Objection To :- The Uniting Kingscliff Redevelopment (SSD47105958)

I live at 37 Drift Court Kingscliff and am a direct neighbour to the proposed Uniting Kingscliff Redevelopment (SSD47105958). I object to the development in its current form based the items listed below.

Figure 1 Planting along and over Boundary Causing over shadow and View loss

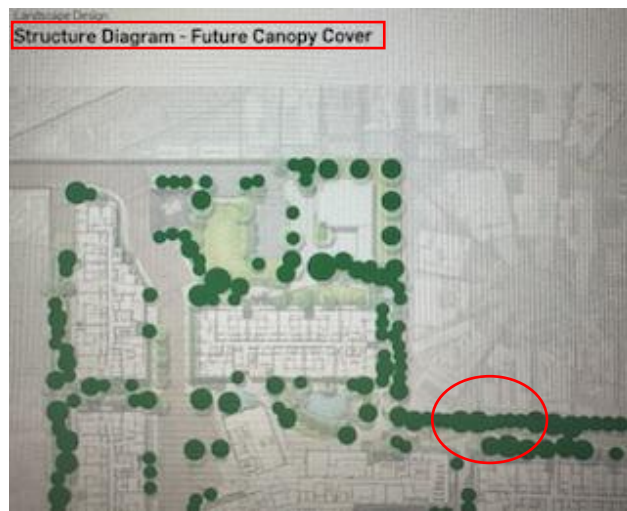
- The landscape design intent presented by the developer, (Appendix AA) shows planting along my boundary and future canopy diagrams appear to have been drawn OVER my boundary.

Figure 8 Misleading as to the impact as it only shows the Rac and Not Building C. Photo is also taken from a location that is least impacted at our house. How does this meet Land and Environment Court's photomontage policy standard?

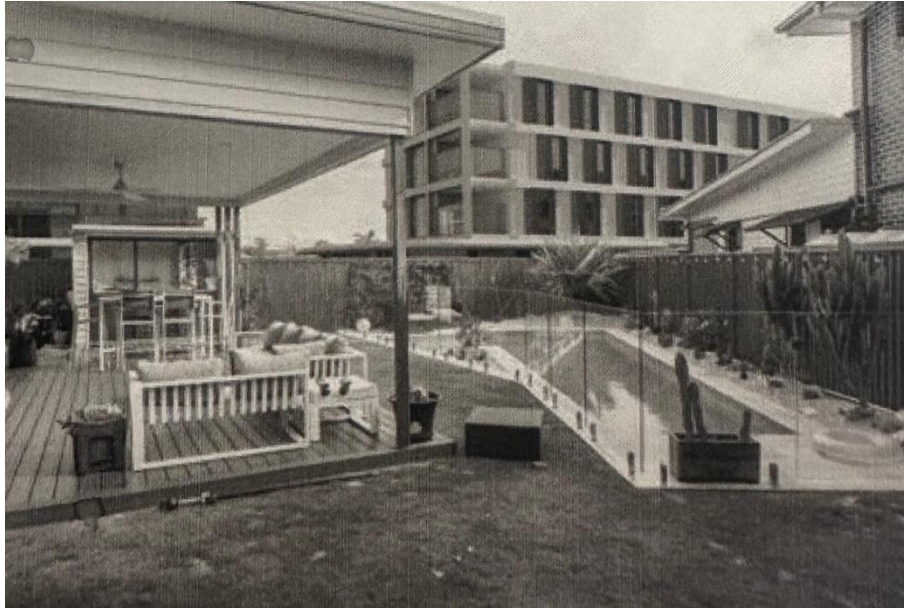
- How they intend to give us privacy
- A true development to the west north west that will accurately show 'building C', not the deceptive presentation from an un-natural view point presented within the View Loss Document.
- Further investigation that shows what we will be looking at west of where our views lie. There is currently a complete out of context picture that that creates an un-natural viewing position.
- A view from all floors back into our property from building C and the RAC. From this, we can see the true effects of view over our property.
- How the use of trees as shown in the Landscape design report will not shade our property nor block any views that may still exist if any.
- Better and more detailed shadow diagrams to show true effects of building in living room, bedroom, entertaining and back yard
- What are the Fence details; height, style, acoustic resilience.

Figure 8 Misleading as to the impact as it only shows the Rac and Not Building C. Photo is also taken from a location that is least impacted at our house. How does this meet Land and Environment Court's photomontage policy standard?

Figure 10 This image shows the outline of House numbers 35 and 37 and will be viewed as one 4 storey, 180 degrees across their western aspect and dominate all views. Note no articulation in buildings.

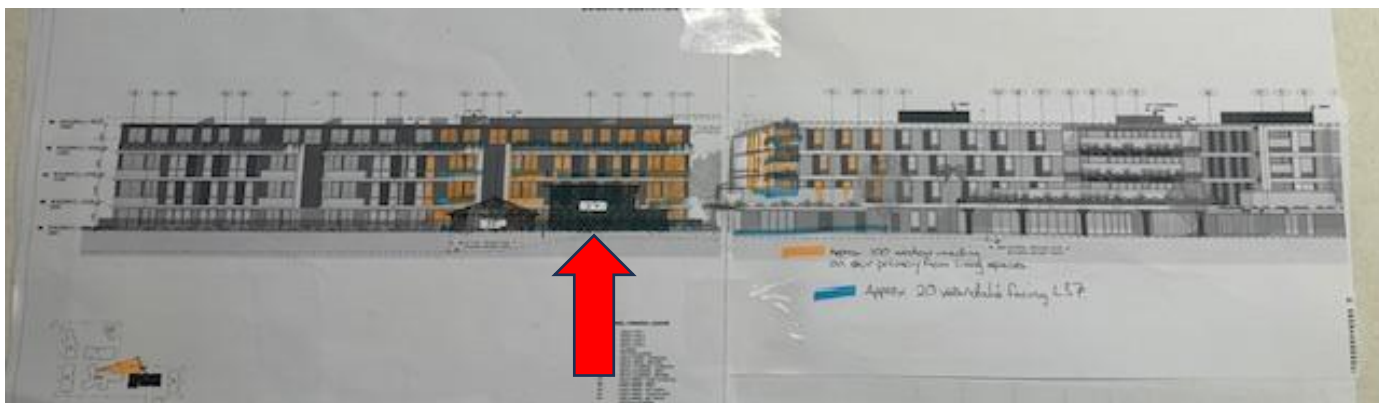
Figure 10 This image shows the outline of House numbers 35 and 37 and will be viewed as one 4 storey, 180 degrees across their western aspect and dominate all views. Note no articulation in buildings.

Figure 11 Overhang of Eave Only Reduced by 450mm How does the developer justify setting back upper level over my property

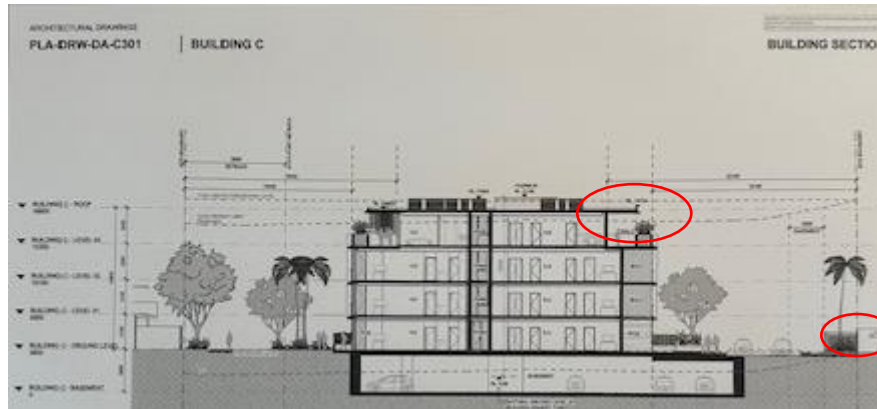
Figure 11 Overhang of Eave Only Reduced by 450mm How does the developer justify setting back upper level over my property

Figure 14 Artist Impression from bedroom not showing entire perspective

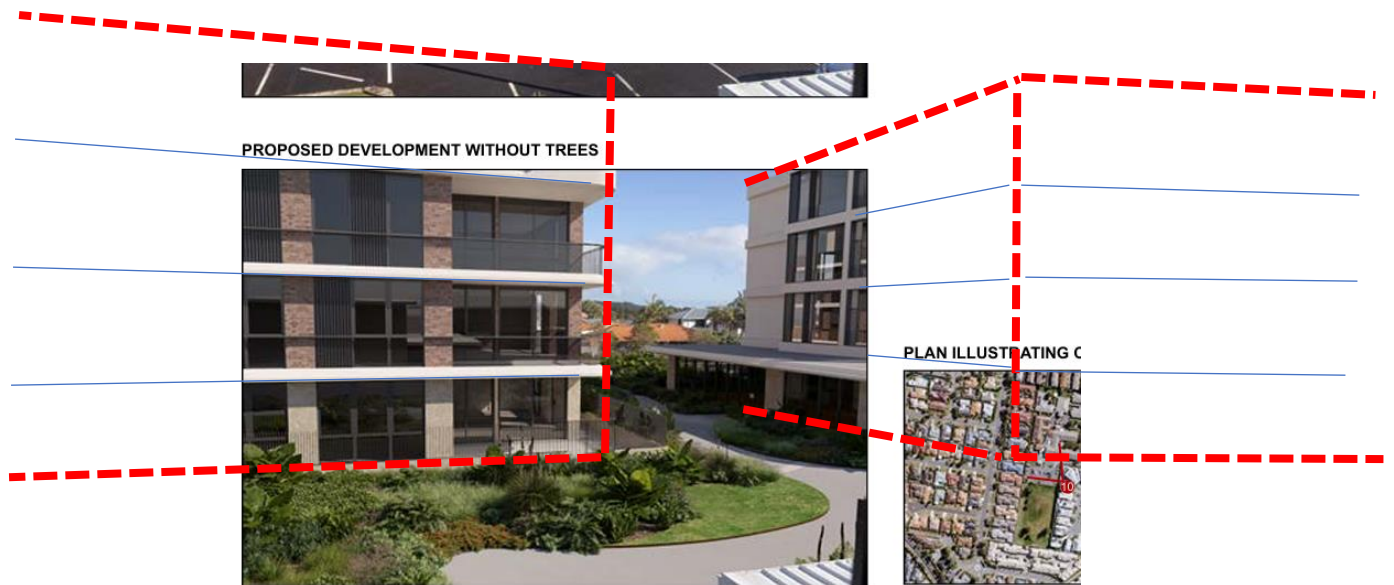
Figure 14 Artist Impression from bedroom not showing entire perspective

Figure 21 Coverage calculated across my boundary

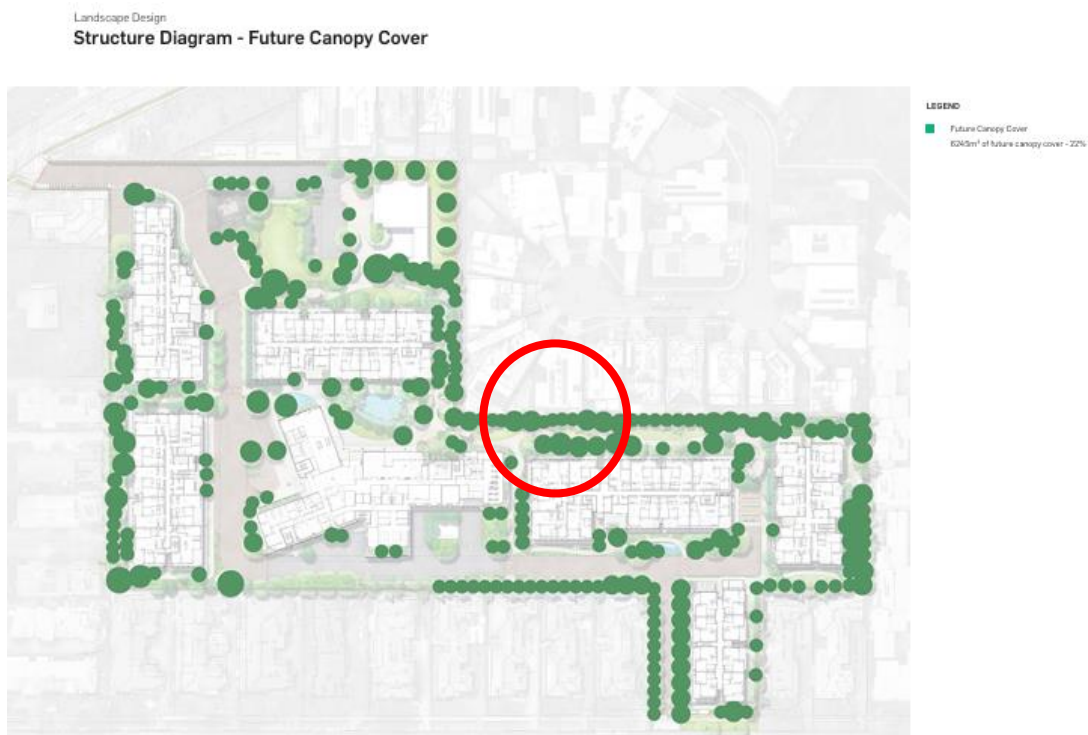
- **Intent to use trees** on our boundary to soften our outlook
- **Trees need to go in deep soil zones** that due to the basement **only exist on our boundary**
- The trees will **block any outlook** we may have and shade our open space and pool making our house **damp and cold** when our house is of passive design designed to absorb warmth in colder months and cool in hotter months.
- Tree coverage has been densified and calculated as tree coverage across my boundary.

Figure 21 Coverage calculated across my boundary

- What are the trees
- Will they create shadow
- Will they block any outlook
- Are these allowed to be used to legally provide privacy.
- How will mature trees grow above the basement

Figure 34 Orange line depicts Natural Ground Level. Local Environment Plan States No development over 13.6 from Existing Ground Level. This sits approximately in this section 1.3-2.0 m above the allowable height and by following the LEP drop off one Level

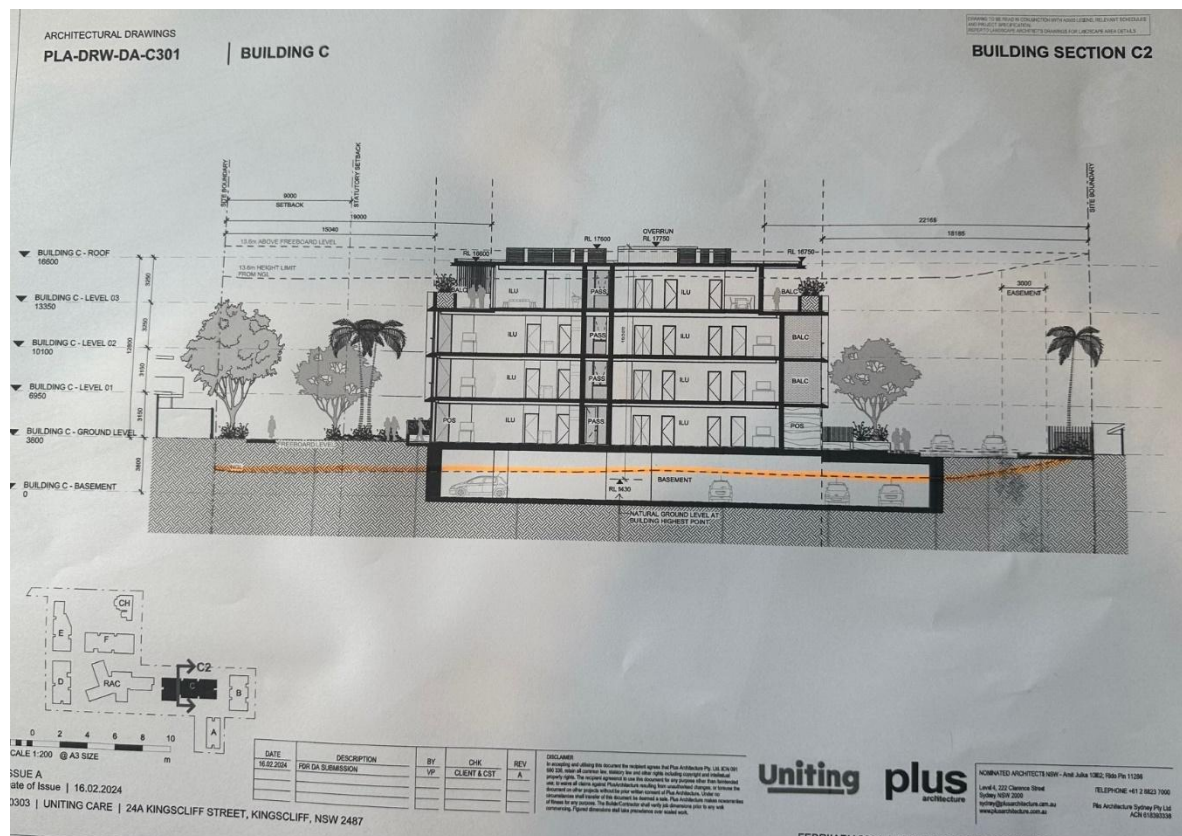
Figure 34 Orange line depicts Natural Ground Level. Local Environment Plan States No development over 13.6 from Existing Ground Level. This sits approximately in this section 1.3-2.0 m above the allowable height and by following the LEP drop off one Level
